Recommendation Report for Planning Permission for Works or Extension to a Dwelling

REF NO: BR/282/20/HH

LOCATION: 34 Bassett Road  
Bognor Regis  
PO21 2JH

PROPOSAL: Removal of existing detached garage and erection of single storey side and rear extension.

sheet 1 of 3

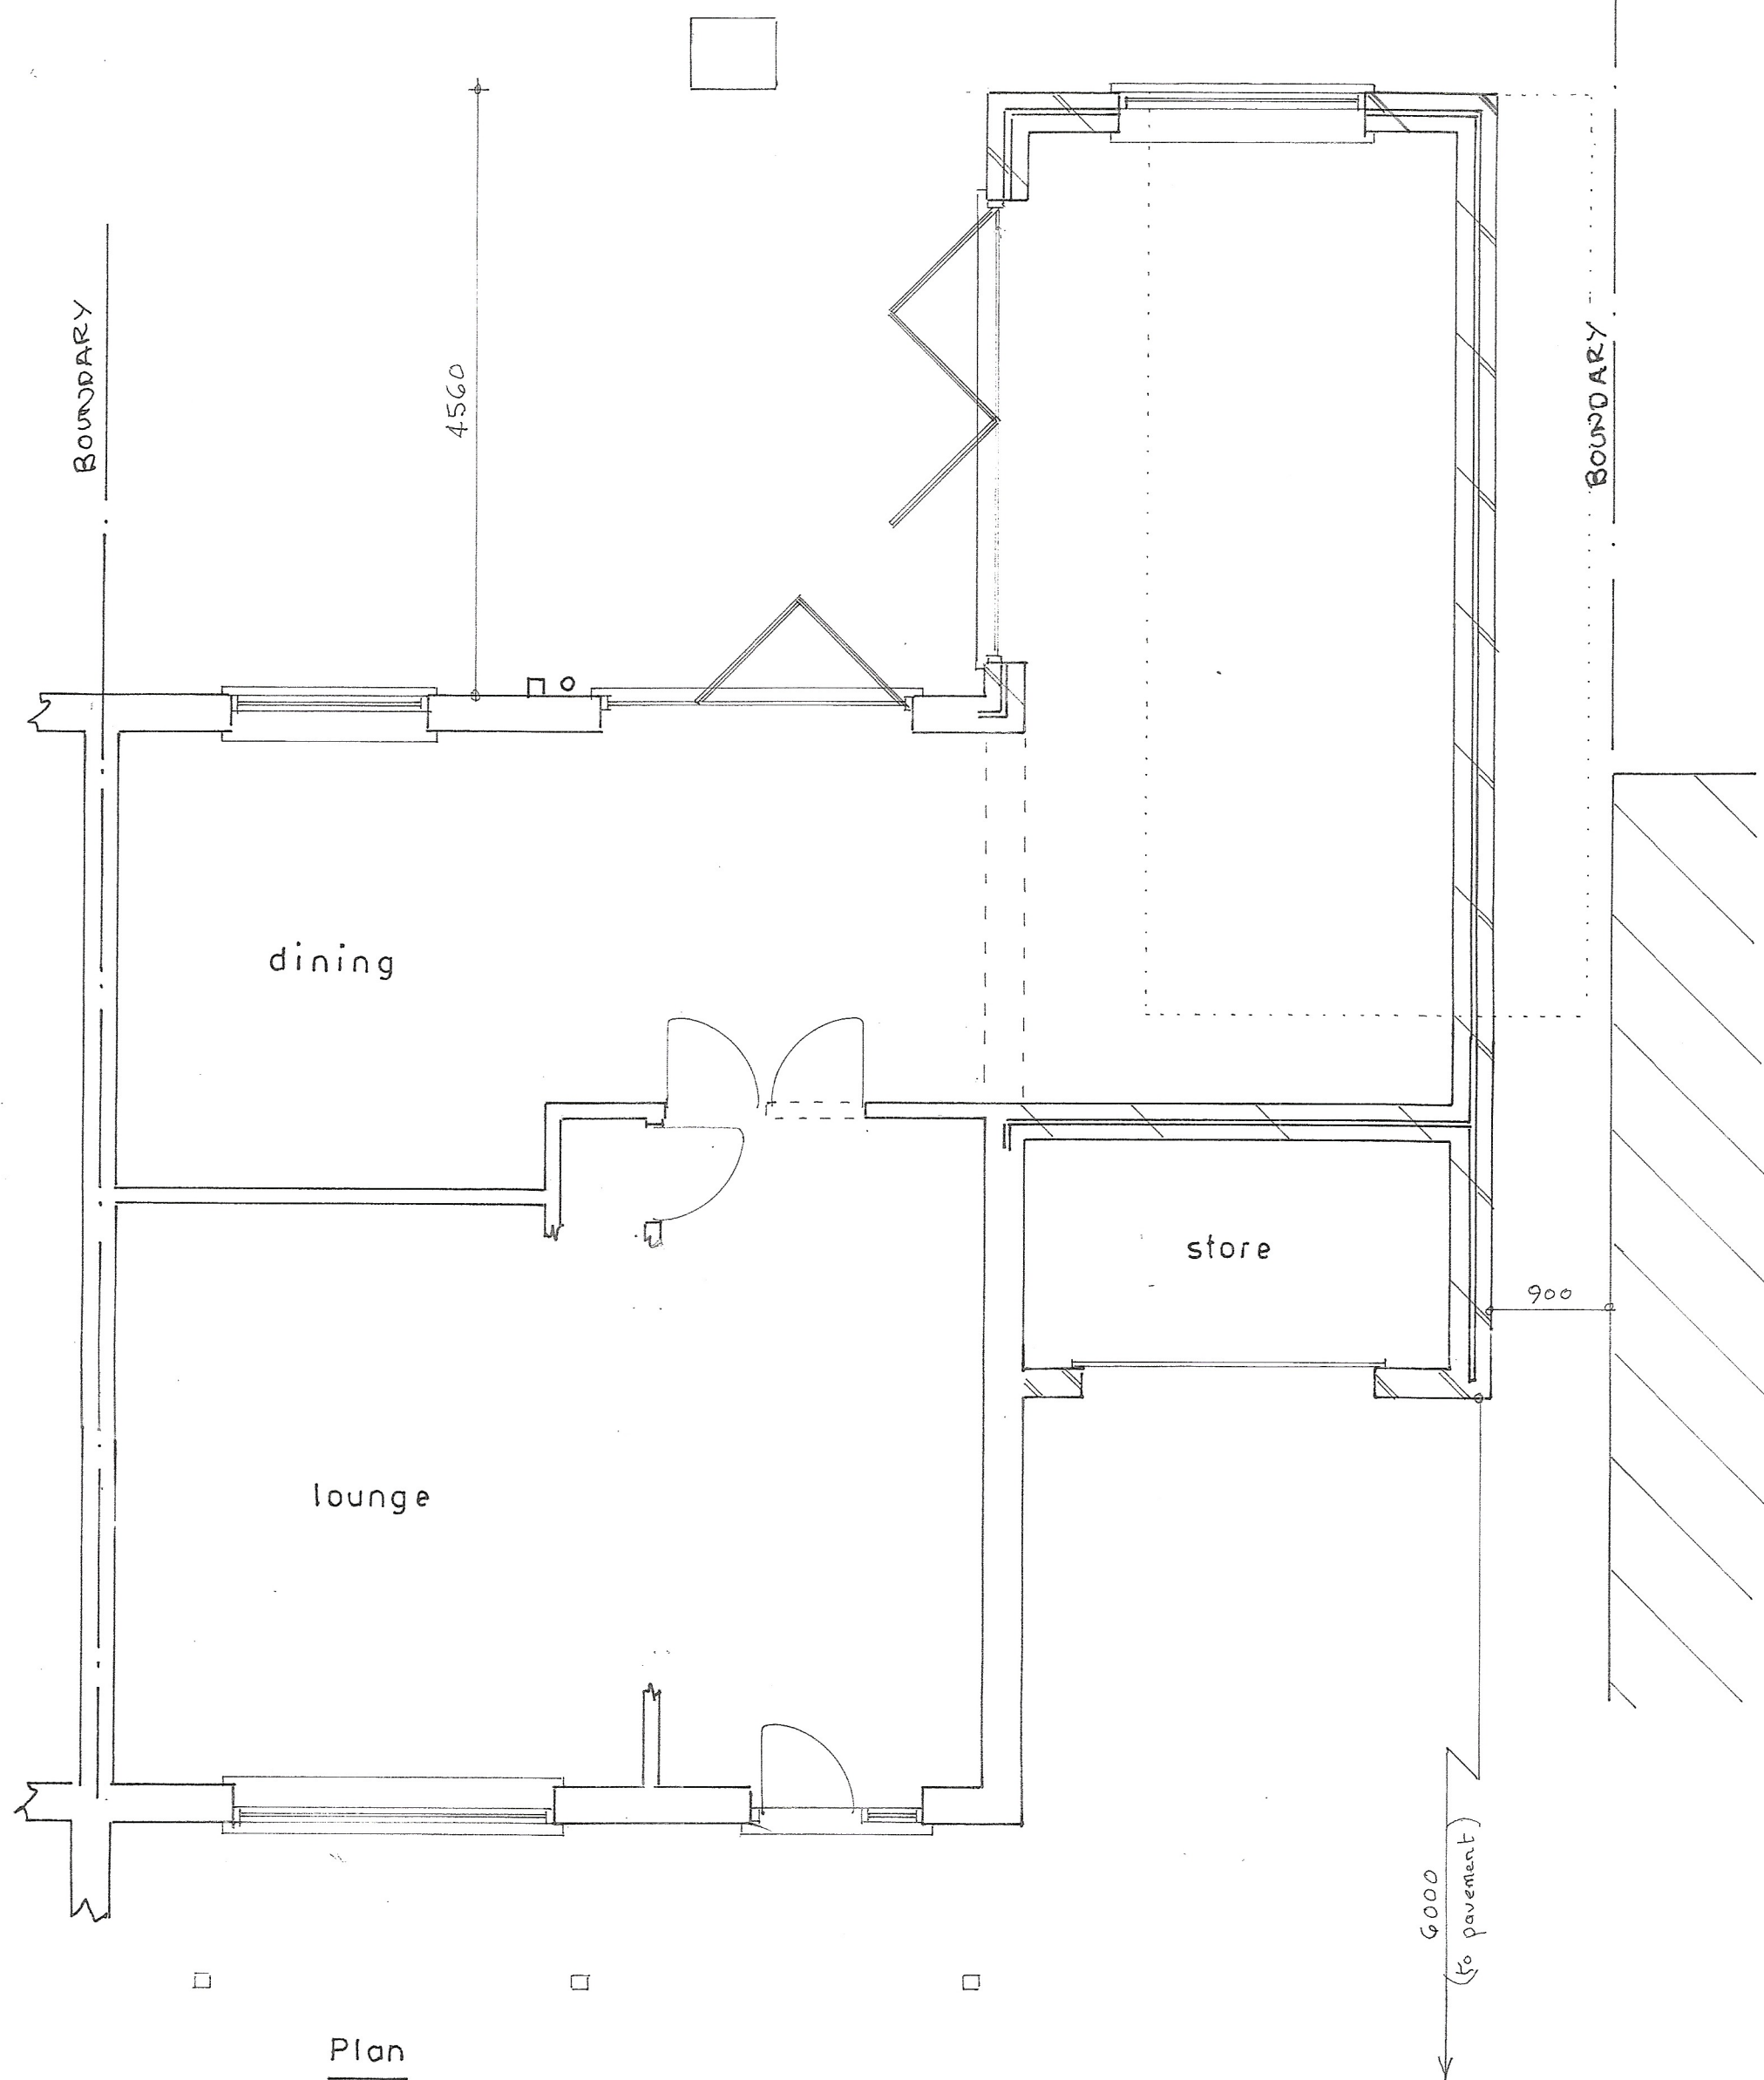
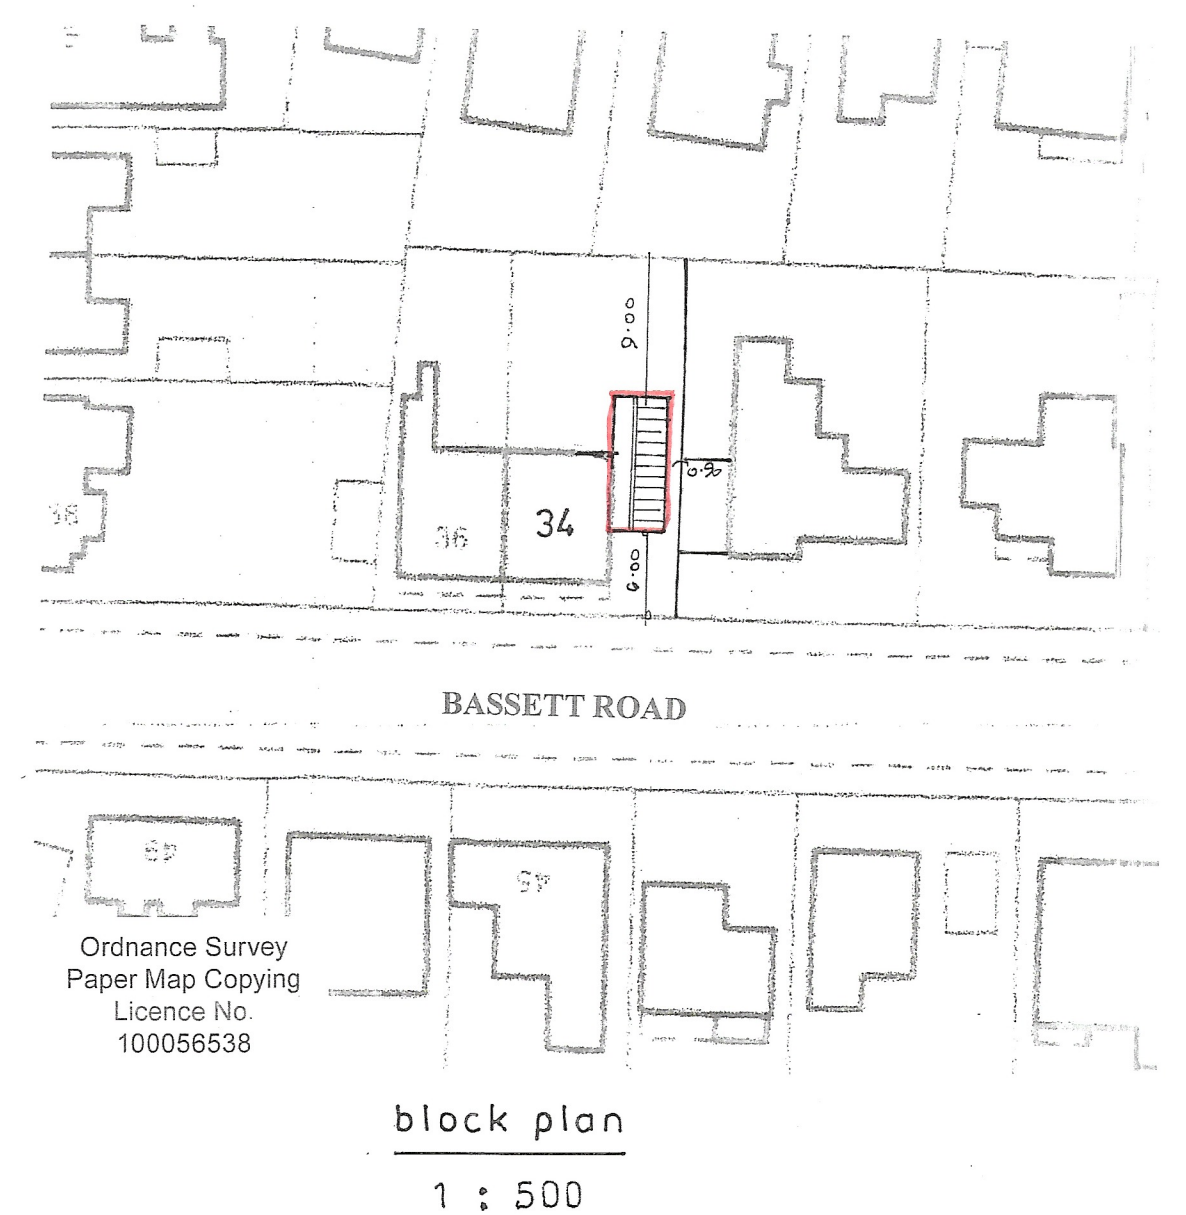
The development to the side and rear is single storey with a partial pitch leading to a flat roof and does not add significant bulk to the property and is a subservient addition. It appears sympathetic in appearance with materials matching the host dwelling. The scale of the dwelling does not increase dramatically with the garage being removed to make way for the extension.

The proposal is modest in size and appears subservient to the dwelling, set back from the principle elevation. It will have flat roof with a maximum height of 4.05m with an eaves height at 2.5m. Whilst the extension to the garage will alter the appearance of the dwelling it is not considered to become an obtrusive feature on the street scene due to the distance it is set back from the front boundary.

The proposal removes the garage and replaces it with an extension running along the east boundary. The roof will be changed to a flat roof from a lean-to. The garage eaves height is 2.5m this means there will be an increase of 0.2m on the boundary with the structure running along the majority of the side and projecting from the rear.

To the front elevation there will be a garage door which will serve a storage room allowing the impact on the street scene to be reduced. To the side there are proposed to be bi-folding doors to allow access to the garden, which overlook the garden of the host dwelling with no views of the neighbouring property available.
